CITY OF PORTLAND

RE: 1738 Washington Avenue, cor. Shepherd Ln -351-A-39 August 26, 1997

Marge Schmuckal
Zoning Administrator

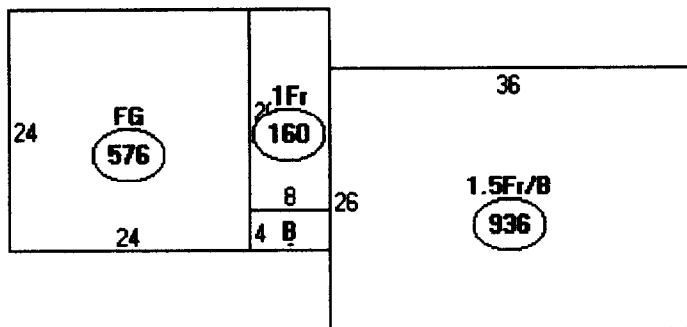
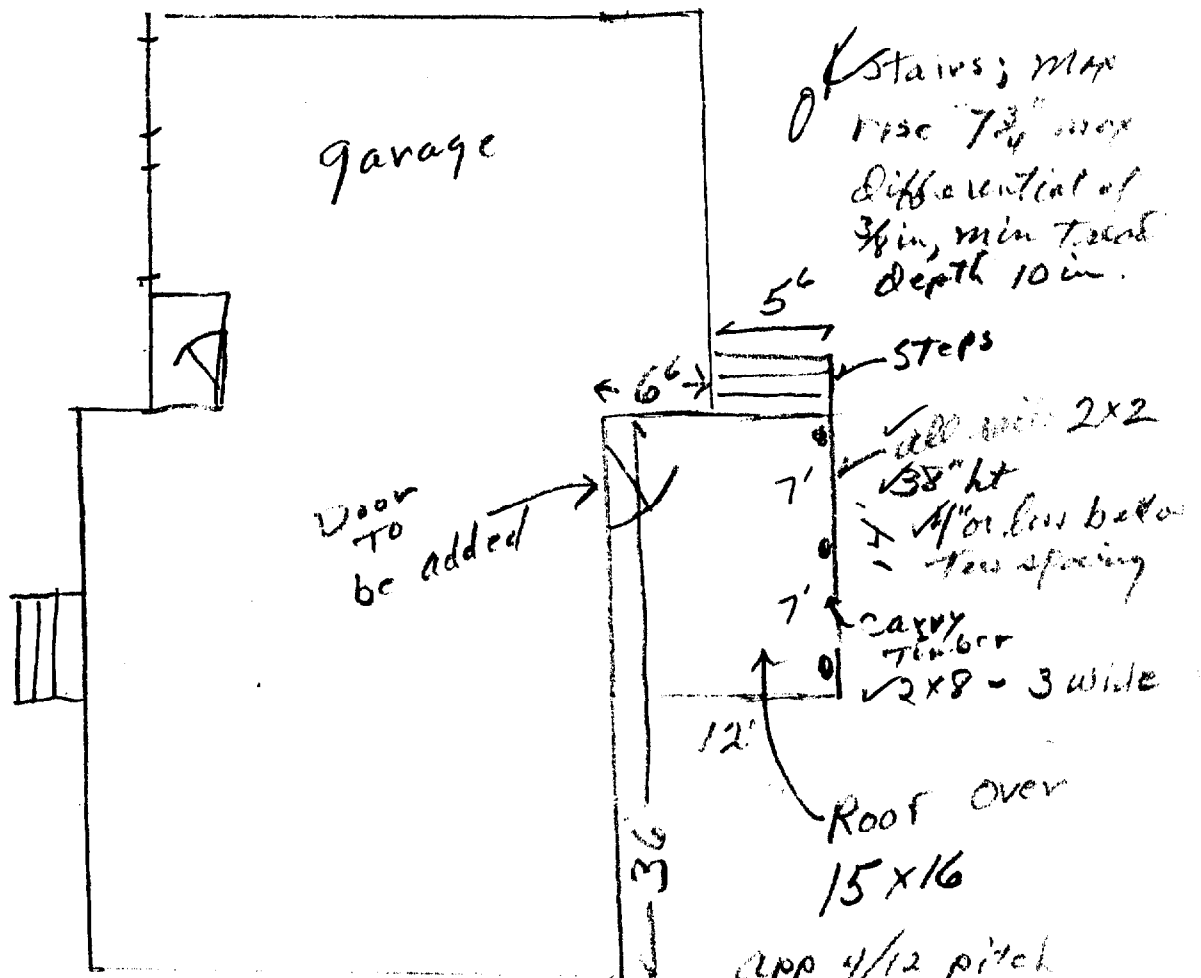
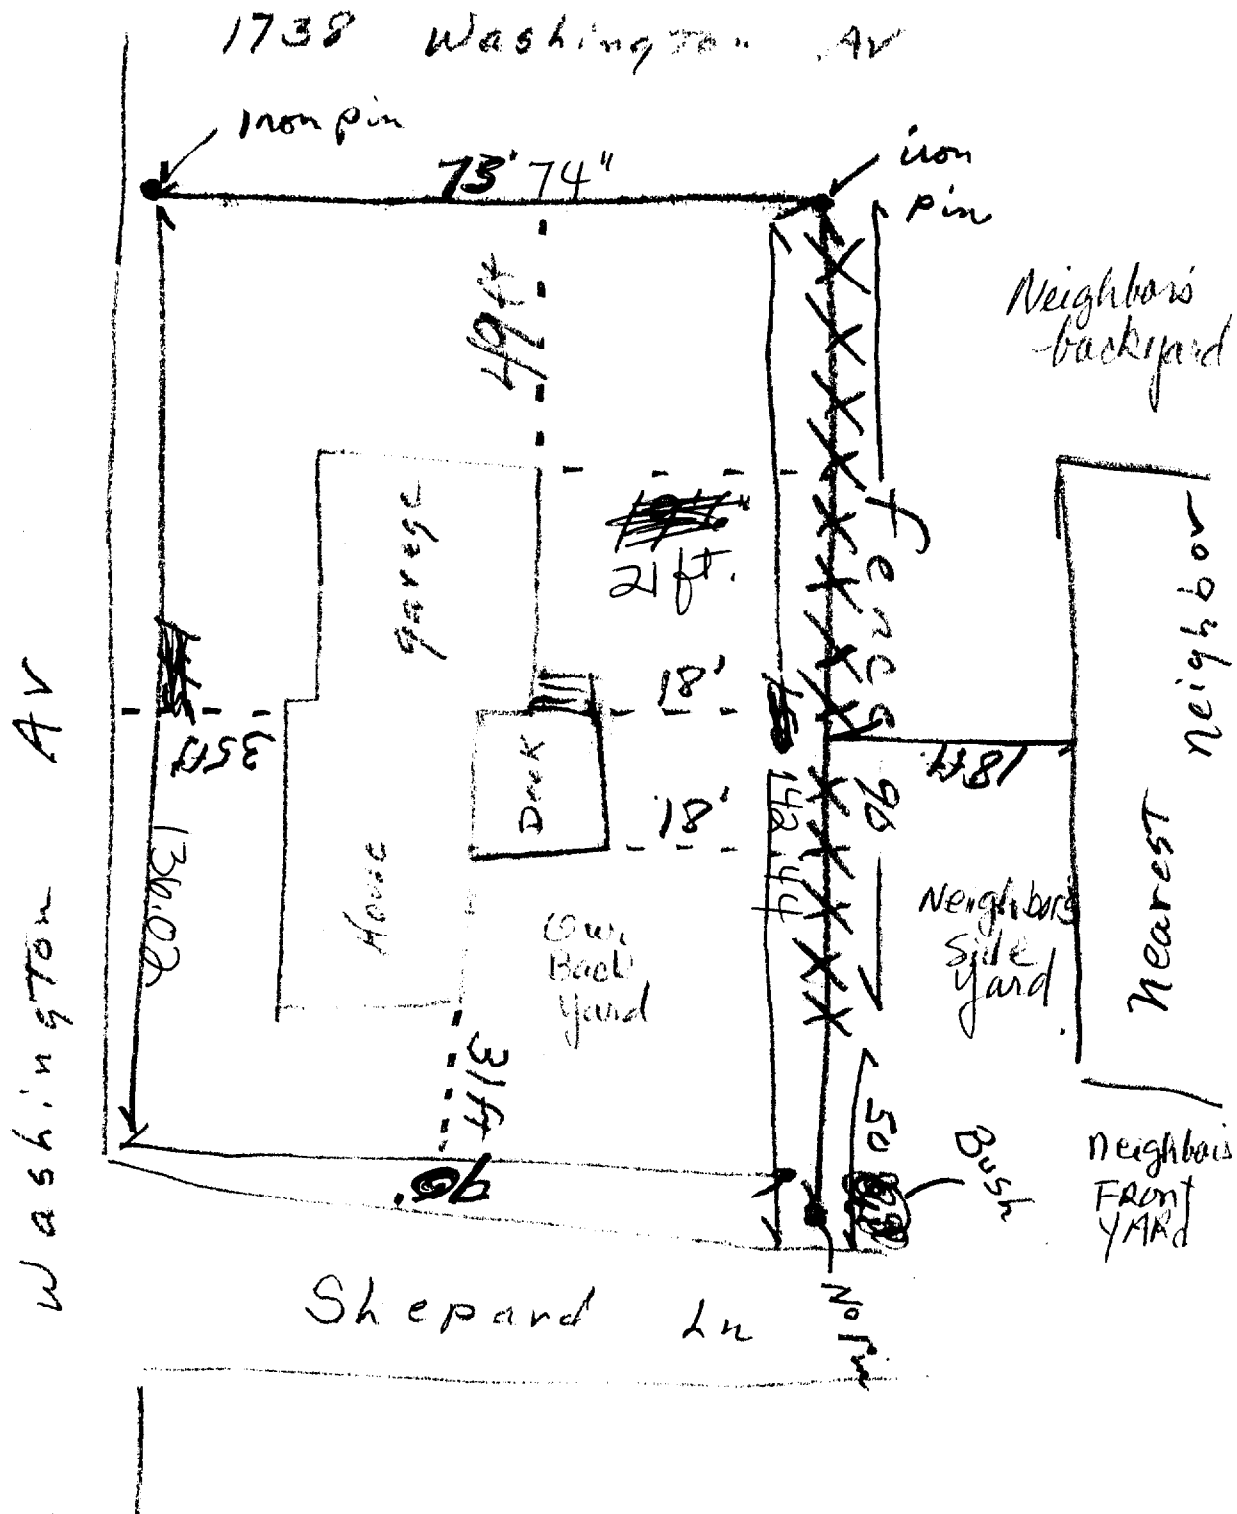
Existing facing long side- aggregate of yards		Required setbacks if facing on short side	
Front yard	25 feet	Front yard	25 feet
Rear yard	21 feet	Rear yard	25 feet
Side yard -rt	30 feet	Side yard -rt	14 feet
Side yard -lft	49 feet	Side yard -lft	14 feet

TOTALS 125 feet is greater than 78 feet
